Application number: 2024/93556	
What is the application for?:	Change of use of land and creation of customer car park
Address of the site or building:	Bolster Moor Coffee Shop, 1A, Bolstermoor Road, Bolster Moor, Huddersfield, HD7 4JU
Postcode:

Type of comment: An objection	
Do you wish your comments to be published on the website anonymously?	Yes
TO BE ANONOMOUS	
NPPF – This is clearly an inappropriate development that impacts the Green Belt and does not constitute ‘Very Special Circumstances’. LDP – the development has clearly outgrown the determination of what farm shop is and does not comply with particular key objectives of the plan. Acumen Planning Statement – A completely biased and client favourable statement, riddled with blinkered views in an attempt to justify the development. The development in the Green Belt that has already been undertaken in part via a temporary planning application and in part with none at all. Still to this day it is being used beyond its temporary approval and should have been subject to an enforcement notice. The applicant is fully aware of the planning process and has either little disregard for the planning process and/or is being ill advised

Existing Site Plan
(1:500)

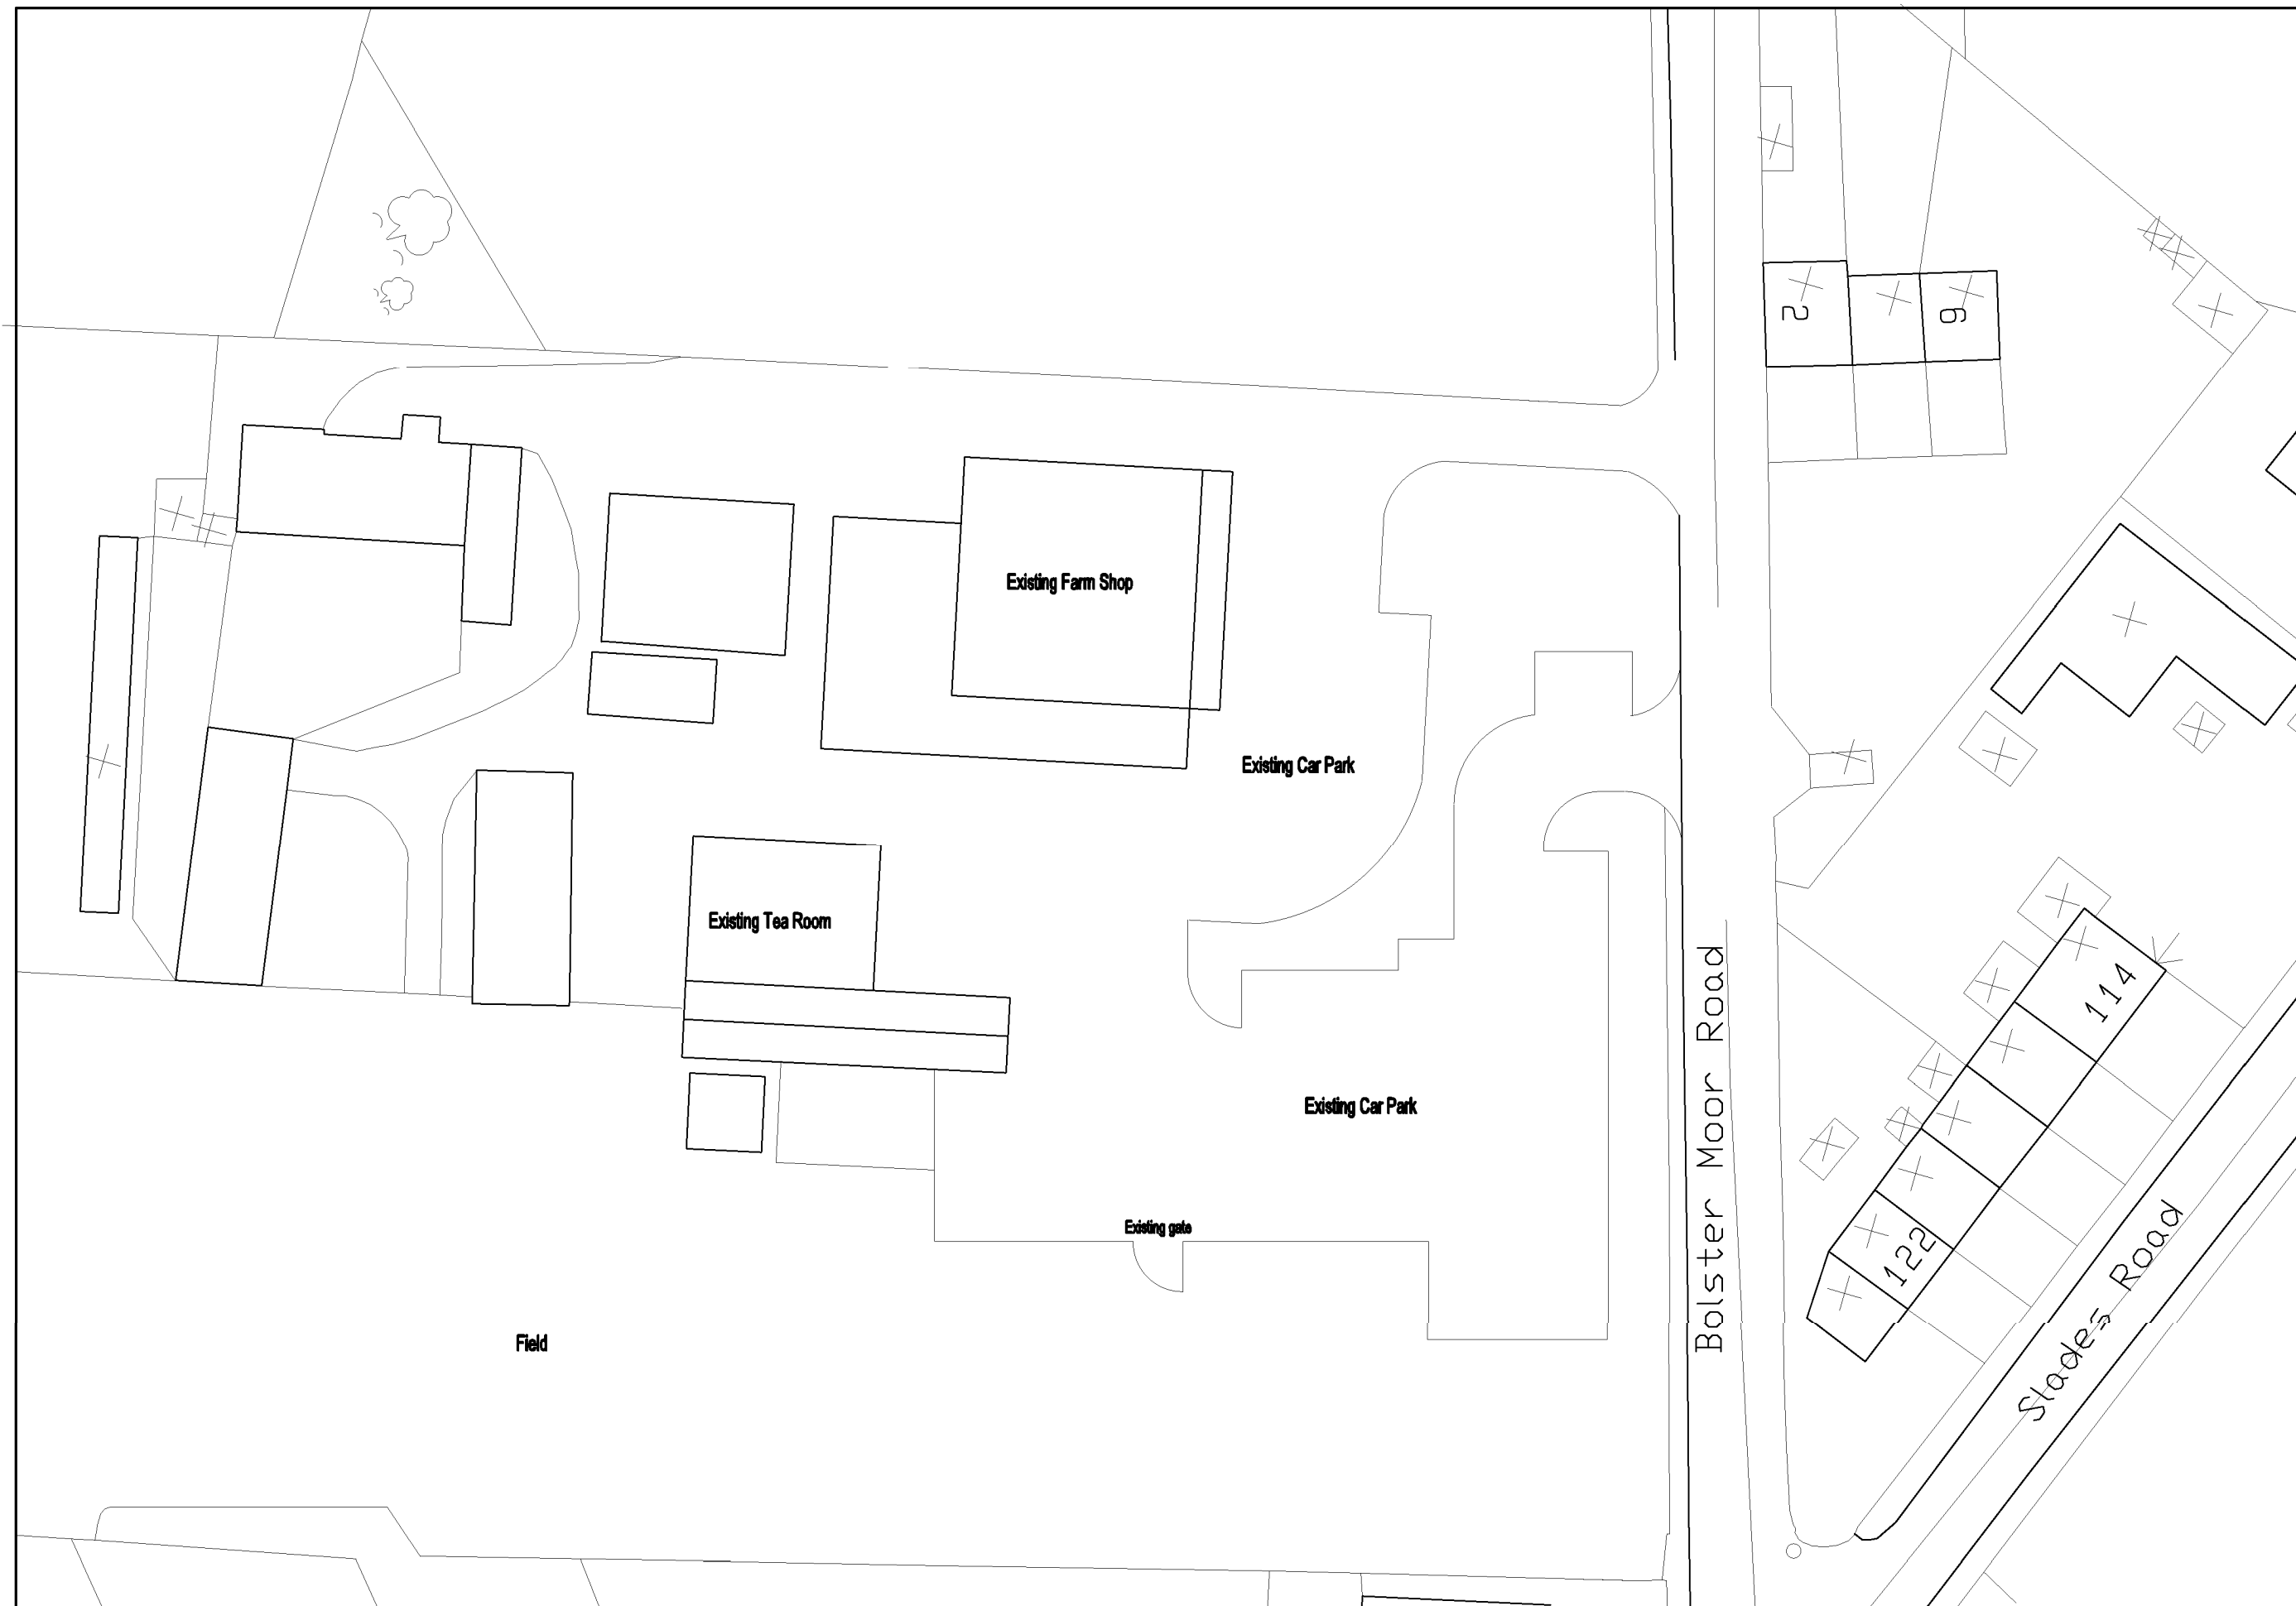
- noise pollution
- air quality
- traffic calming measures – signage generally including lit attention speed signs, speed tables, 20mph zoning, High Friction Surfacing
- Visibility assessments for access and egress into the development which is currently extremely poor due to on street parking by staff. The use of double yellow lines will assist with visibility.
- Residential Permit parking or timed parking 2hours no return
- Impact to local Bus services

It appears no considerations have been taken relating to robust materiality, drainage, attenuation, EVCP's, pedestrian movement, inclusive design, cycle provision,

landscaping, promoting public transport, public open space and lighting.

The installed construction to circulation routes is of aggregate with fines in and the parking areas are simply a Plastic Cellular Paver embedded into soil. This does not comply with any design guide for a permanent car park solution. The car park visually is extremely poor and only after being used for a short period is showing signs of serious wear with rutting to parking spaces. This mud and fines during the xmas period trailed all the way through the car park on to the highway. I have doubts a civil engineer was consulted for the construction and that the CBR criteria isn't being met for loadings including for Emergency Services loadings. There also doesn't appear to be any drainage including petrol interceptor strategy in place and discharge point. Have the LLFA been consulted?
